Proposed extension to rear elevation. Demolition of garage & provision of new with carport. Proposed porch.
14 Manor Close Felpham

Thank you for your internet representation made on 22nd April 2015 which has been recorded as **'an objection'** with the comments as follows:

PROPOSED SIDE ELEVATION 1:100

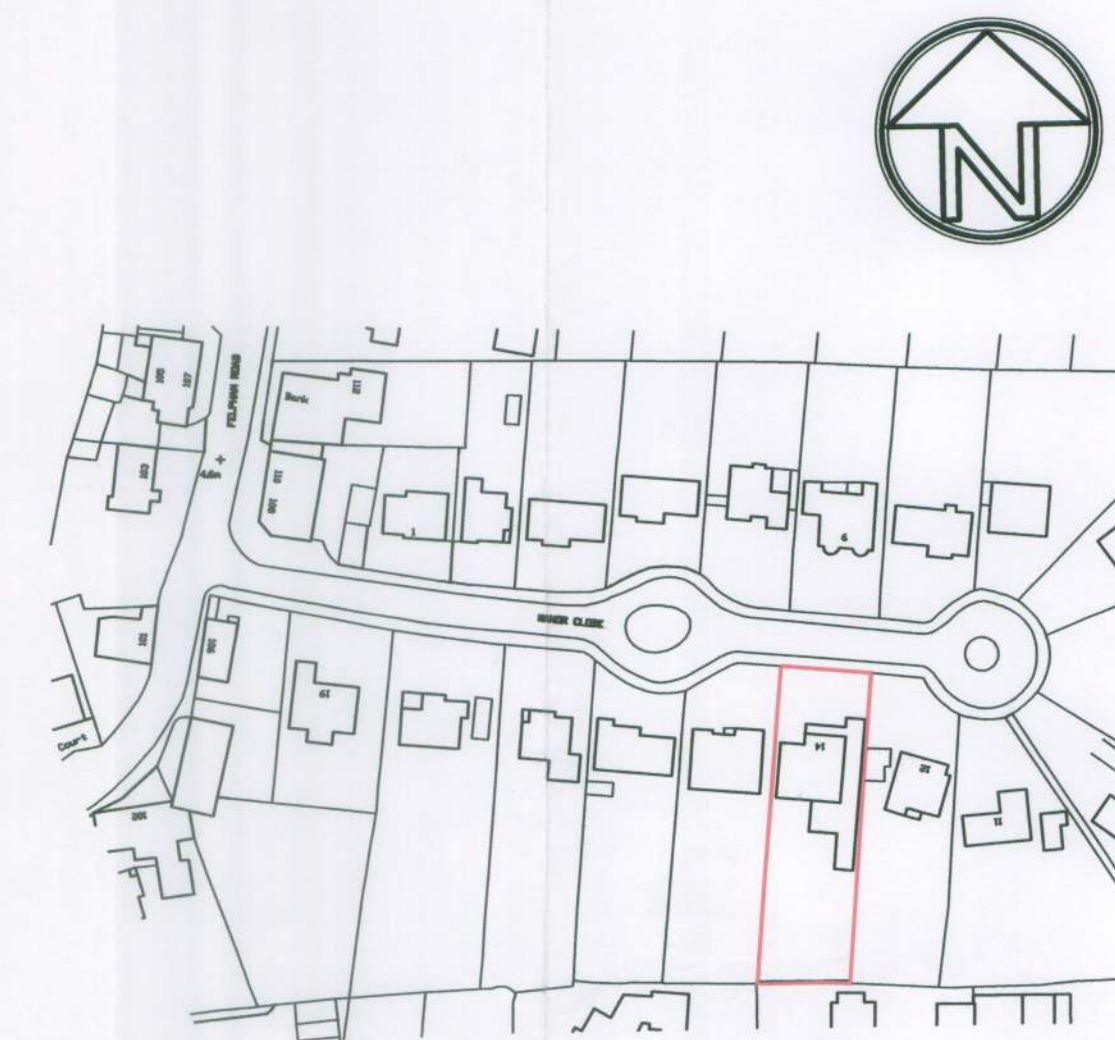
The WC window facing our property, be it clear or opaque, open or closed, is not acceptable and an invasion of our privacy.

The height of this proposed structure on our boundary will affect the maintenance of our property. The proximity of this large single story construction will adversely impact on the view from our lounge, patio and garden.

ROOF PLAN PROPOSED 1:100

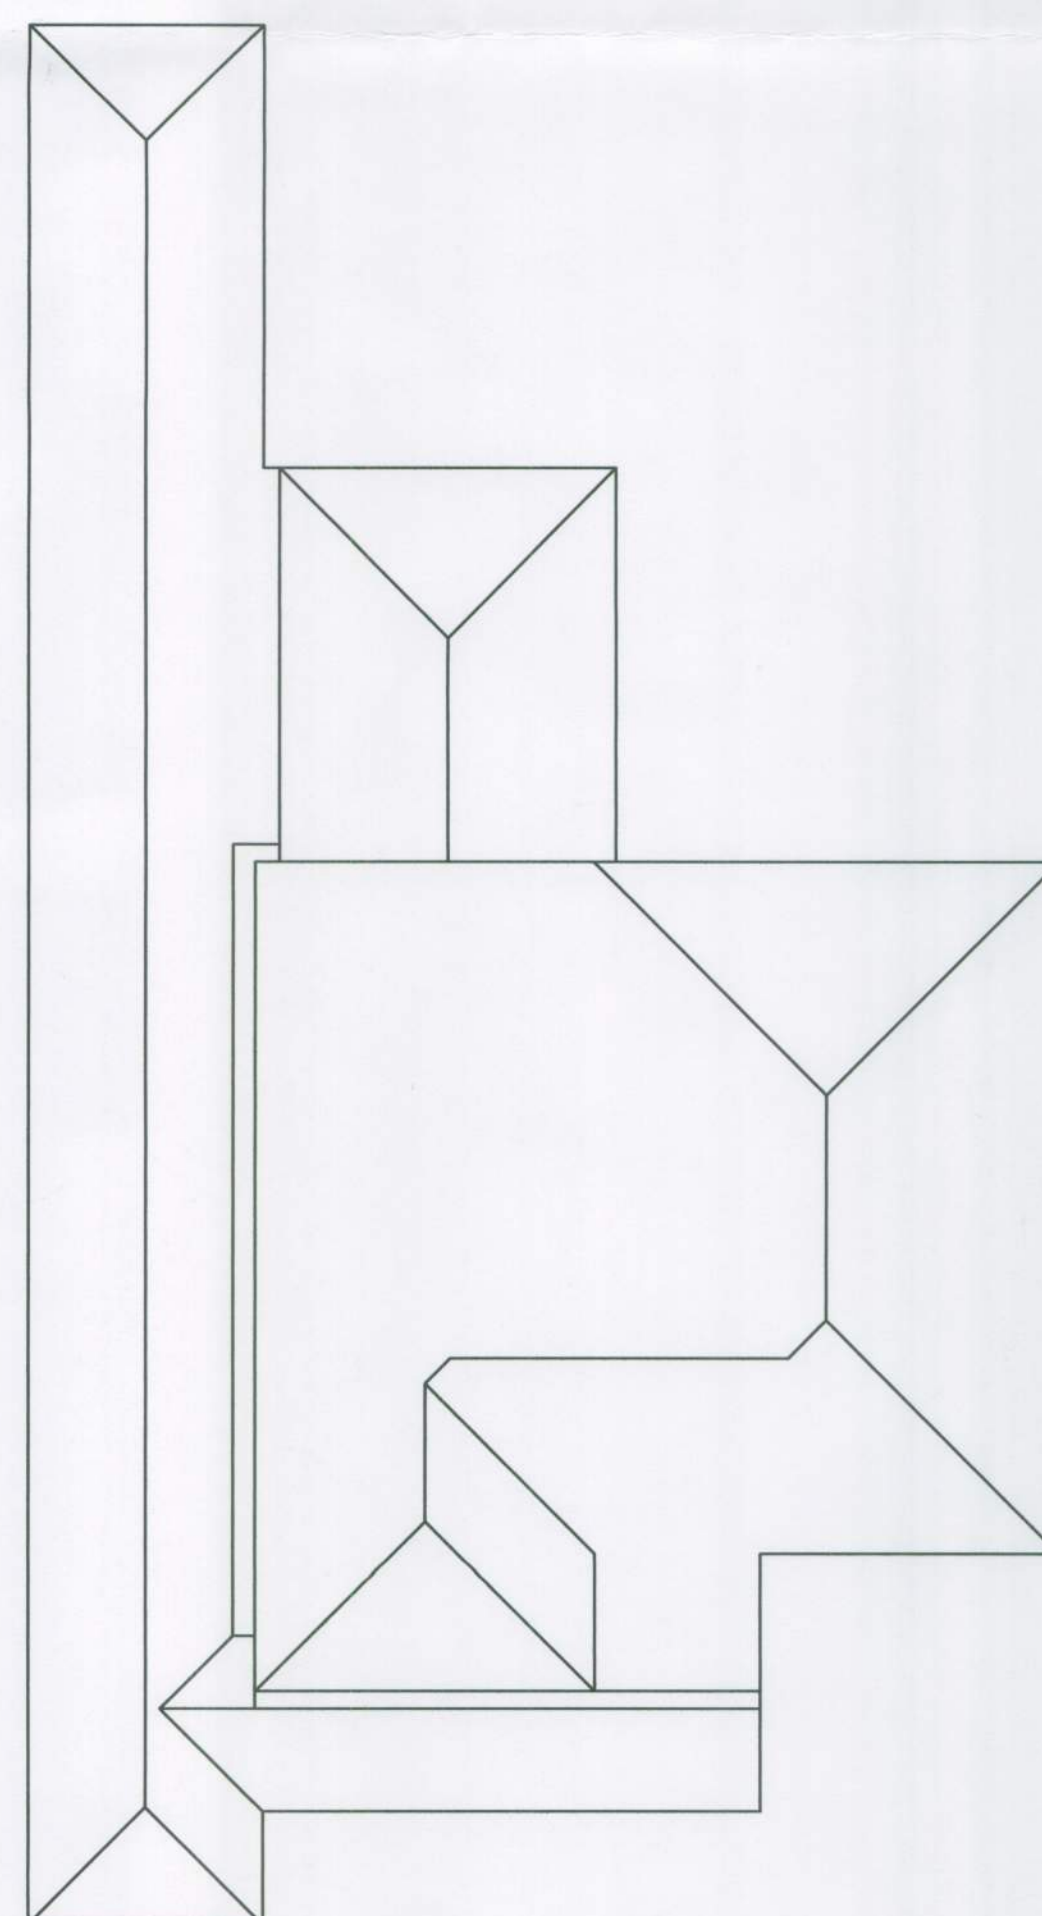
Due to the very close proximity of the proposed carport roof and gutter to our garage it would make it impossible for us to carry out general maintenance to the west side of our garage.

The vast roof size alongside our boundary is approximately 80 feet in length giving us grave concern on rainwater management.
